# IMMINGHAM EASTERN RO-RO TERMINAL

Proposed Changes Notification Report

Document Reference 10.3.2

PINS Reference – TR0300072023

Drawing number
B2429400-JAC-00-ZZ-DR-ZZ-0201

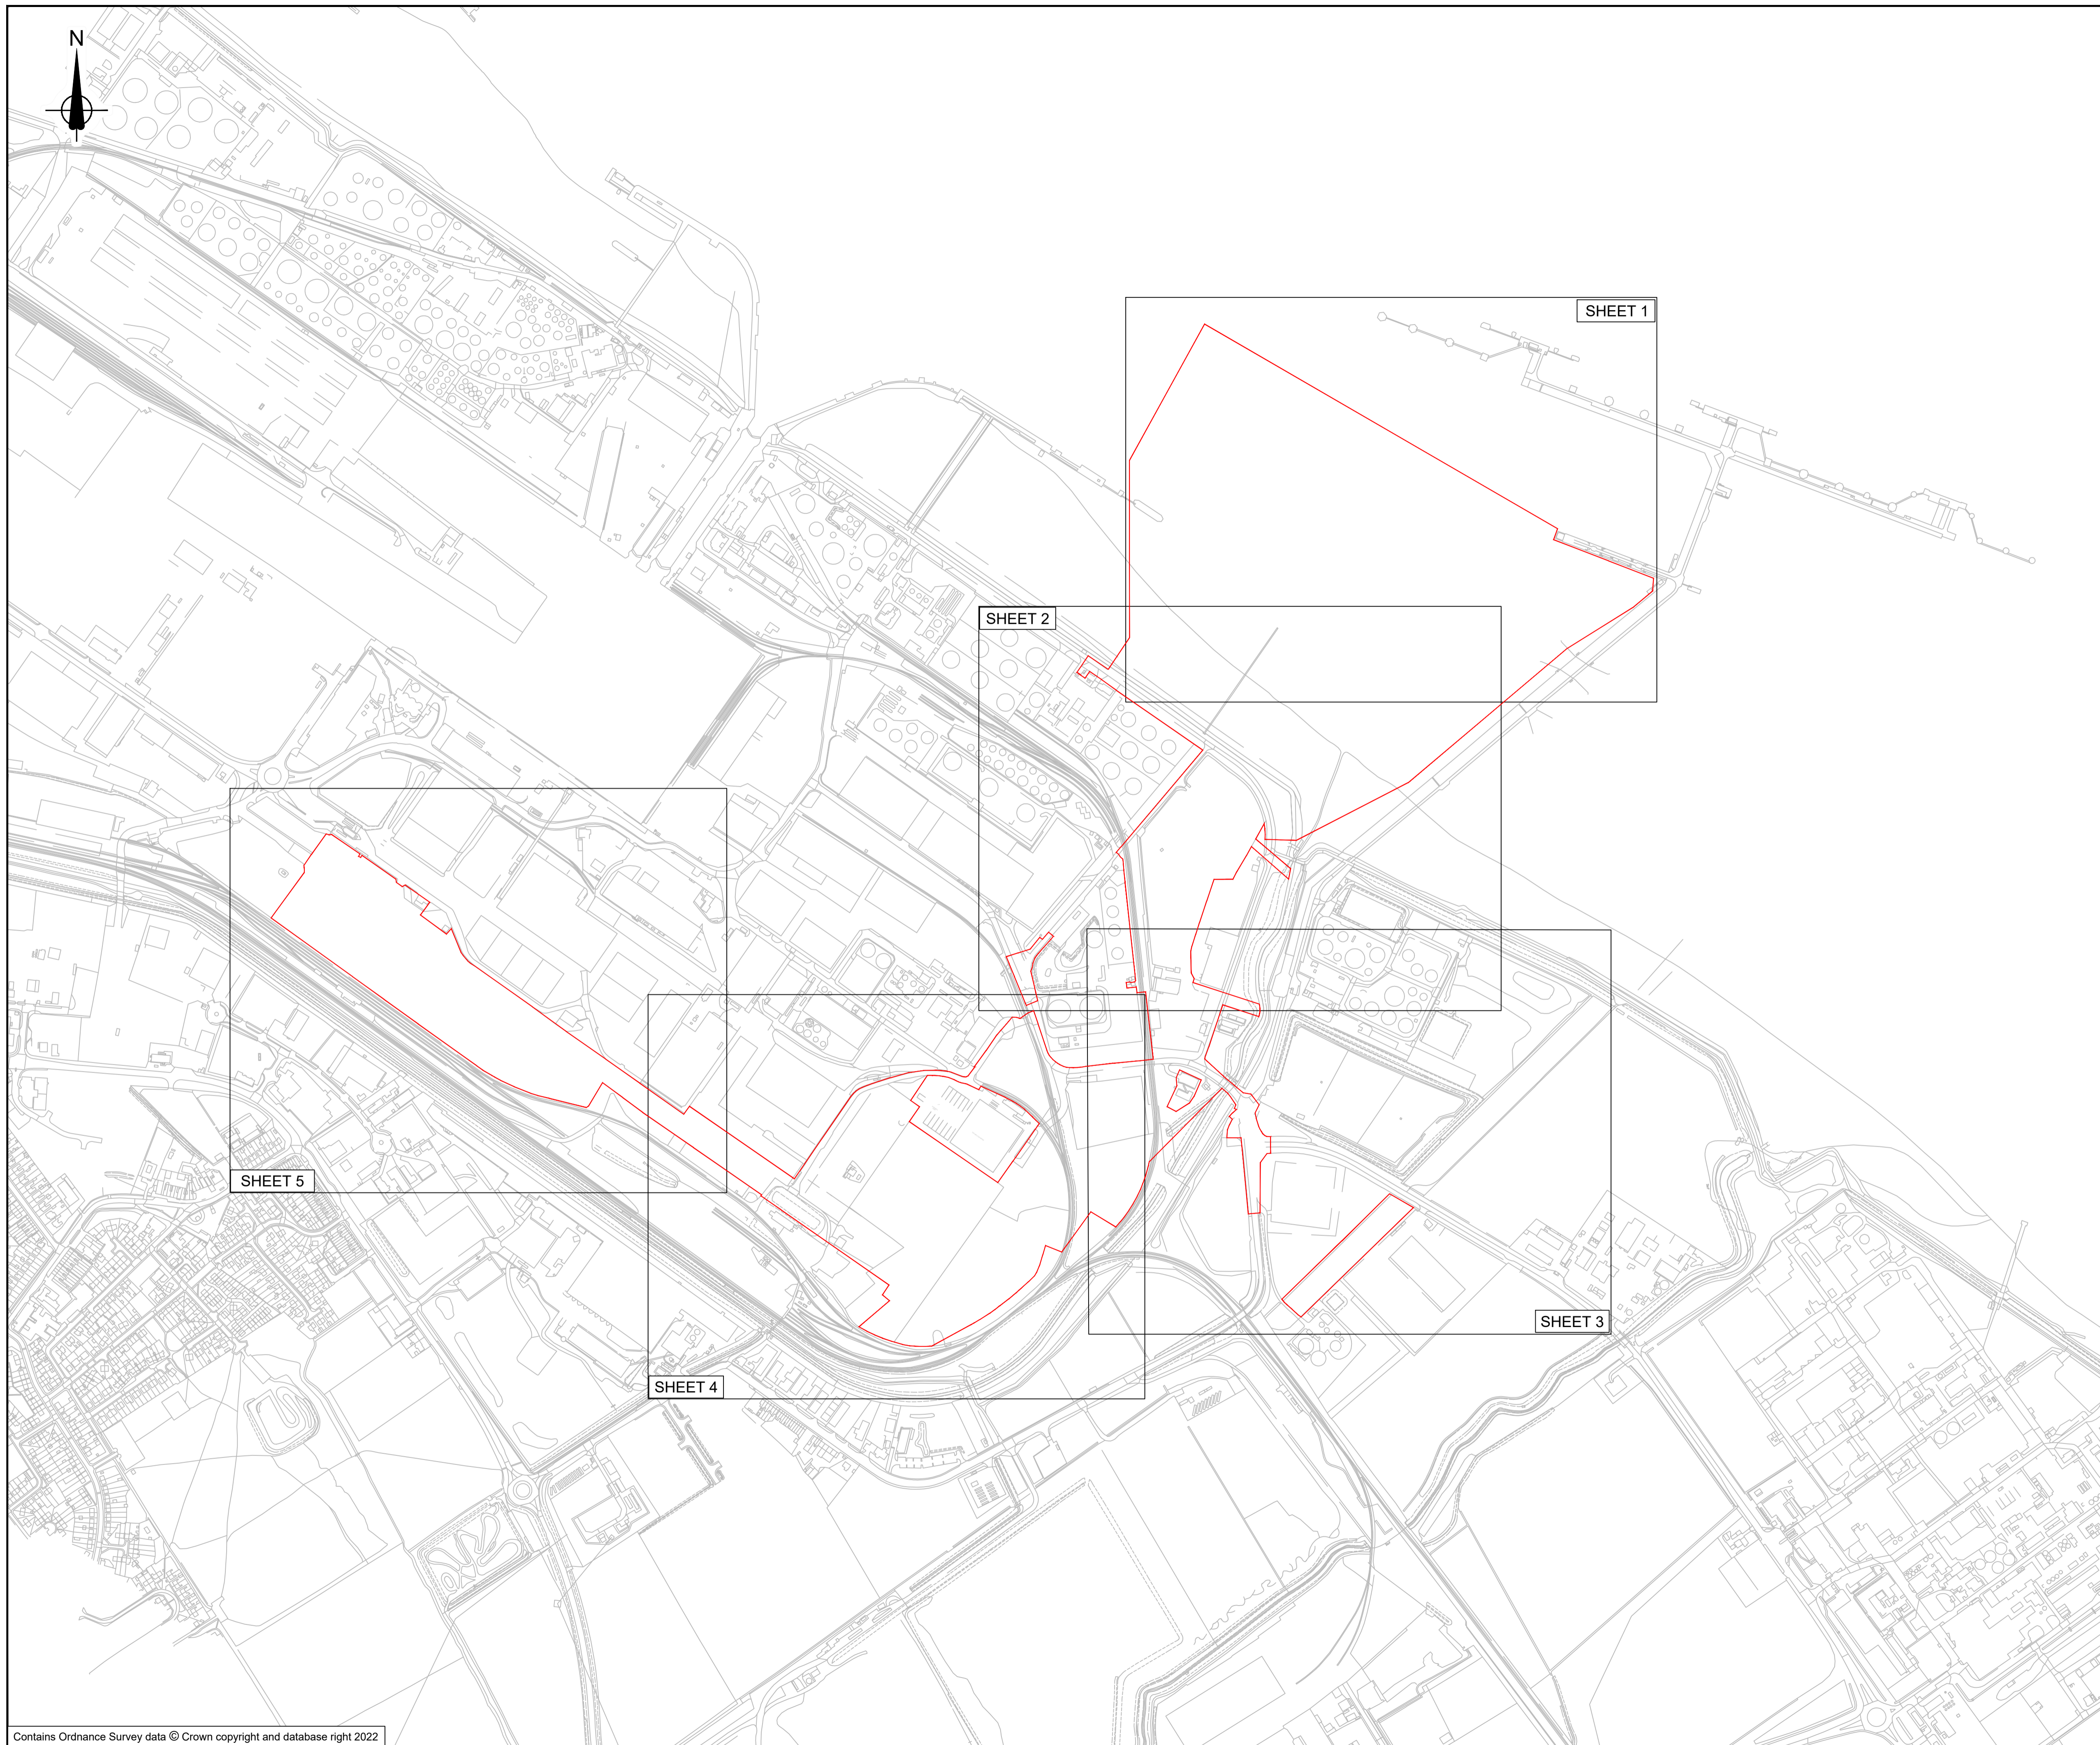
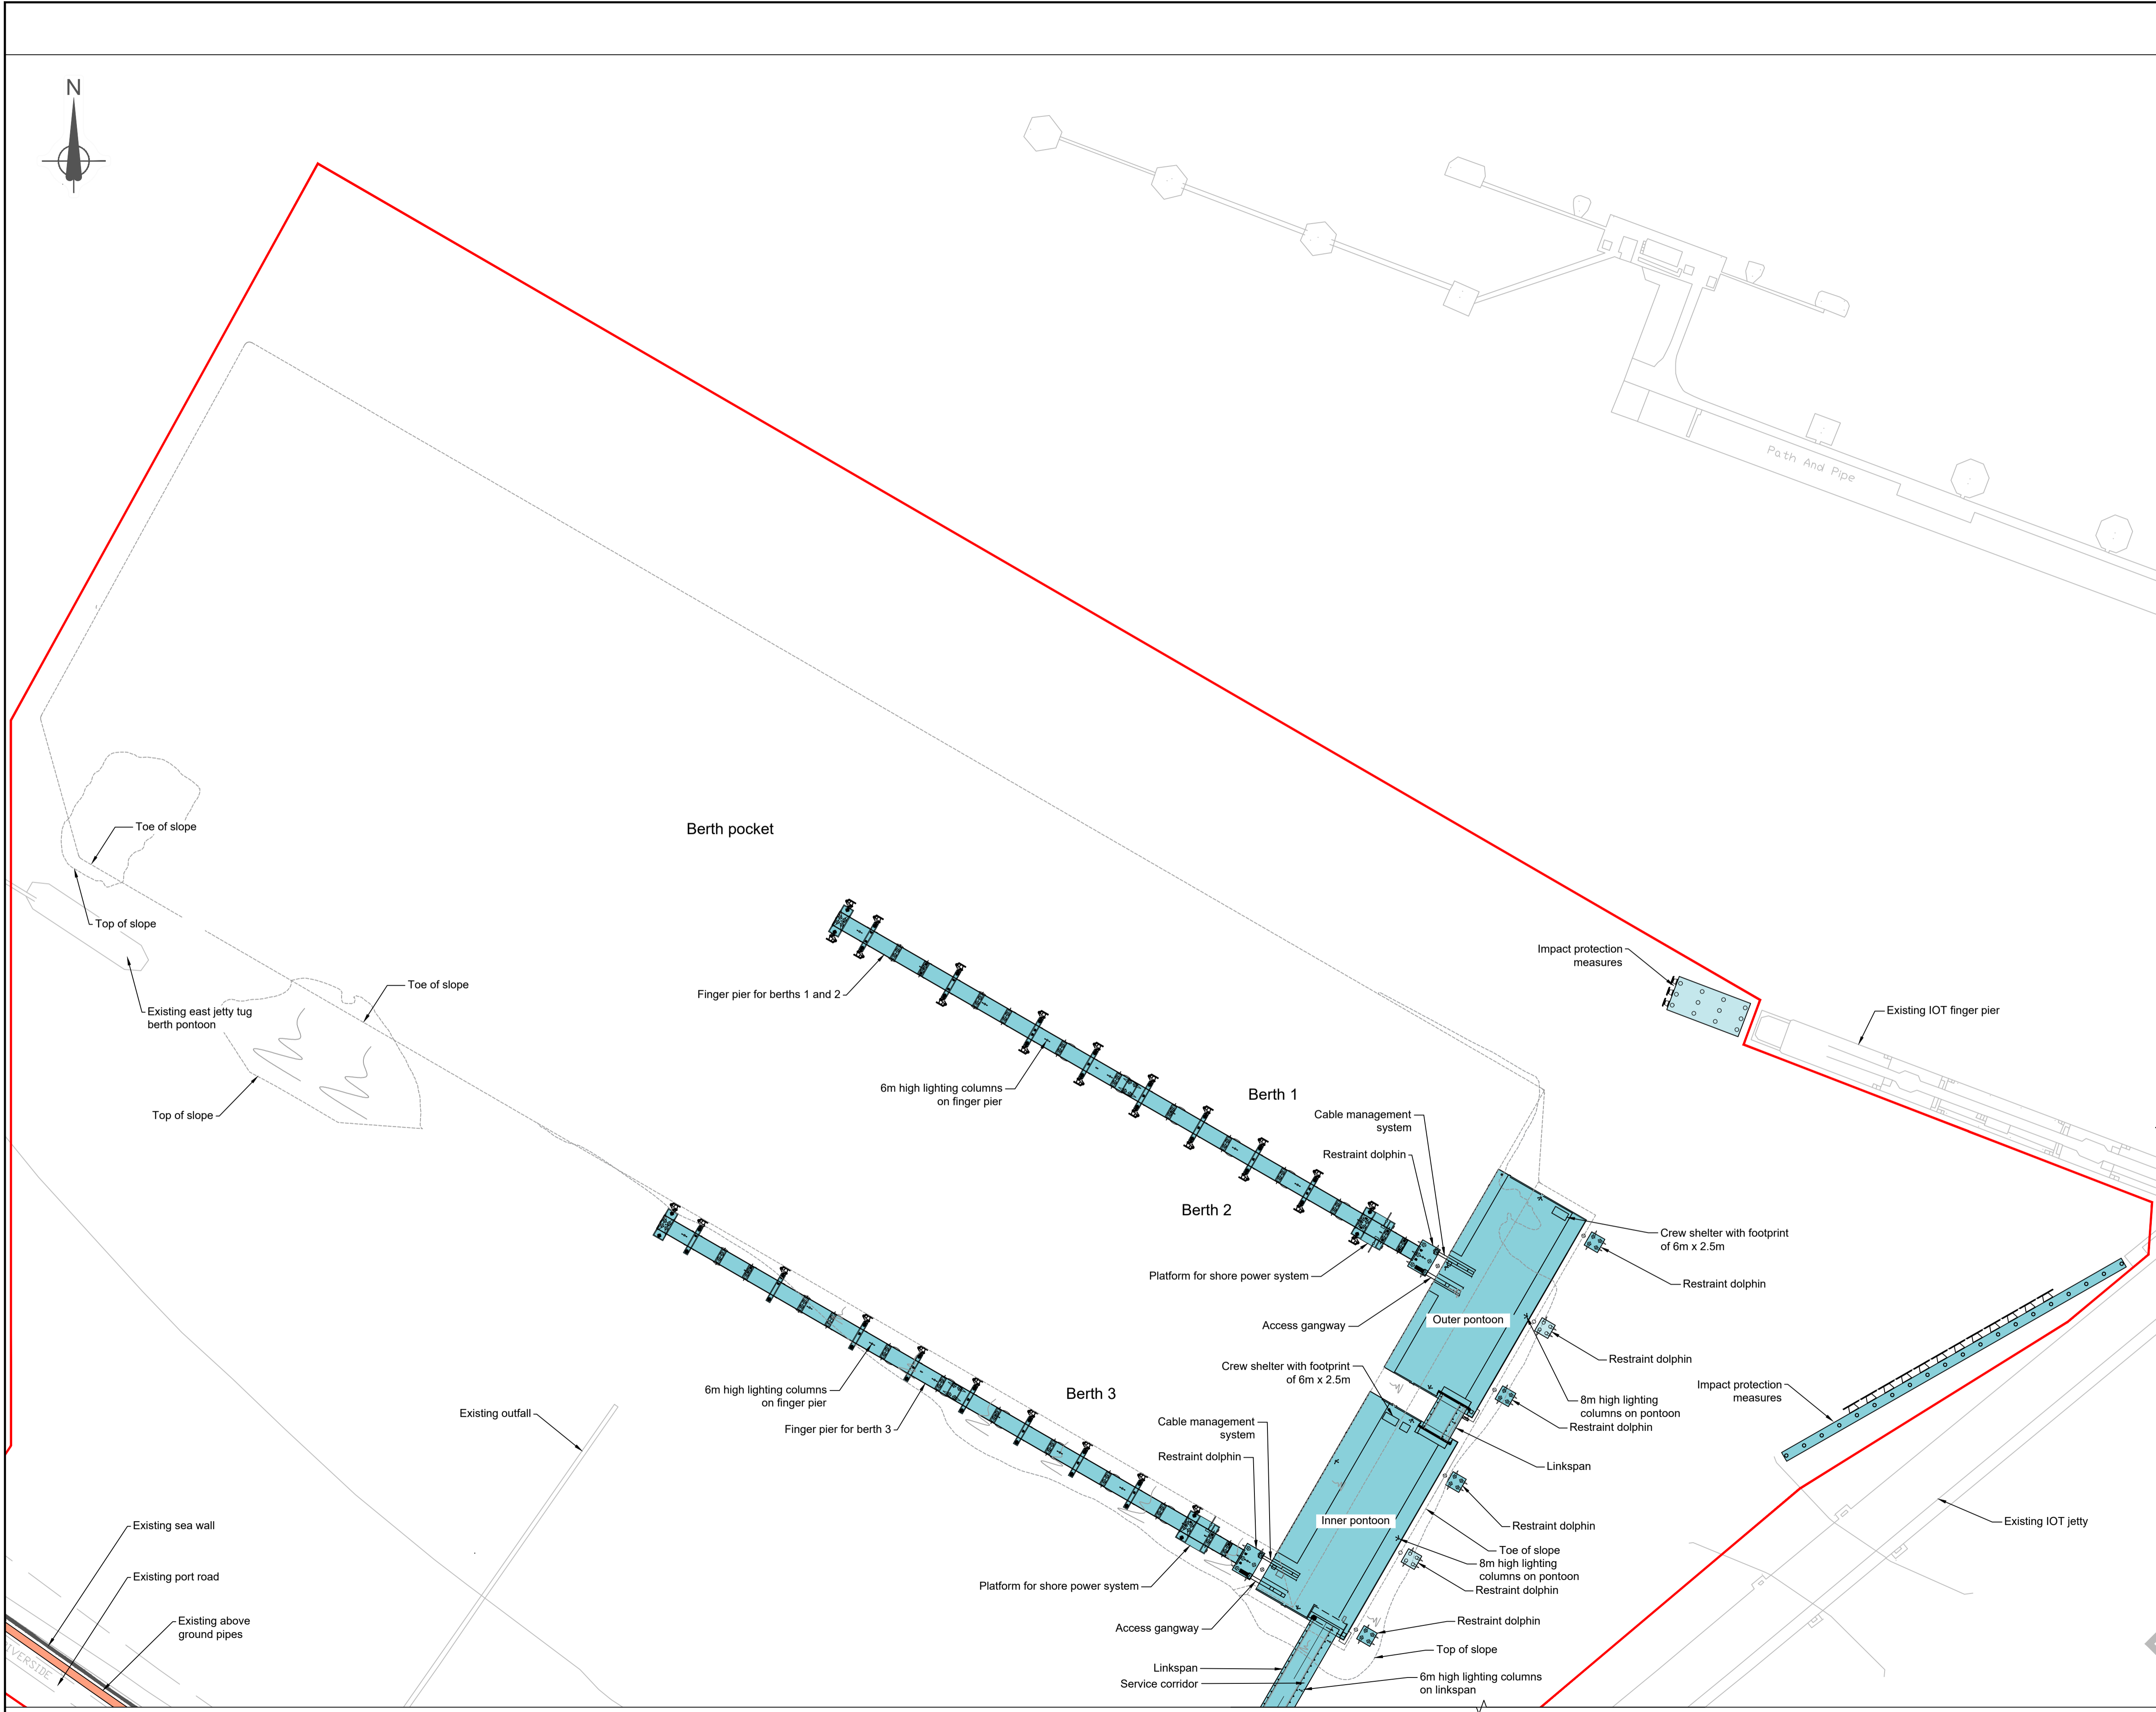
- 2.11 **Approach jetty** – the approach jetty has been straightened for efficiency from the alignment originally submitted, thereby accommodating an improved swept path for vehicular movement whilst at the same time moving the approach jetty away from IOT marine infrastructure. The realignment has also facilitated a repositioning of some of the piles leading to a slight reduction in the number of piles used.

- 2.12 **Bridging of foreshore pipelines** – at the interface between the landside and the approach jetty, the jetty structure has been raised from the design originally submitted to enable ease of access/inspection of the pipes running under the new jetty.

- 2.13 **Restraint dolphins** – up to two additional restraint dolphins are proposed for each of the landing pontoons to improve stability. The environmental effect of the increase in the number of piles required for the restraint dolphins has been assessed as minimal – this is outlined in the ES Addendum (Appendix 1) at paragraphs 7.2.3 - 7.2.8 and 9.2.6 - 9.2.9.

- 2.14 **Finger pier adjustments** – two additional piles to support bollards above, have been added to the Proposed Development's finger piers to improve mooring performance. In addition, the platforms serving both finger piers have been enlarged to facilitate the provision of the shore to ship power equipment. The additional piling required has been assessed to identify whether there is likely to be a change to the conclusions on environmental impact set out in the ES. The conclusion is that any additional impact will be minimal – as detailed in the ES Addendum (Appendix 1) at paragraphs 9.2.6 - 9.2.9.

- 2.15 Figures 1 and 2 below show how the originally submitted scheme would be amended if this proposed Change 1 is accepted.
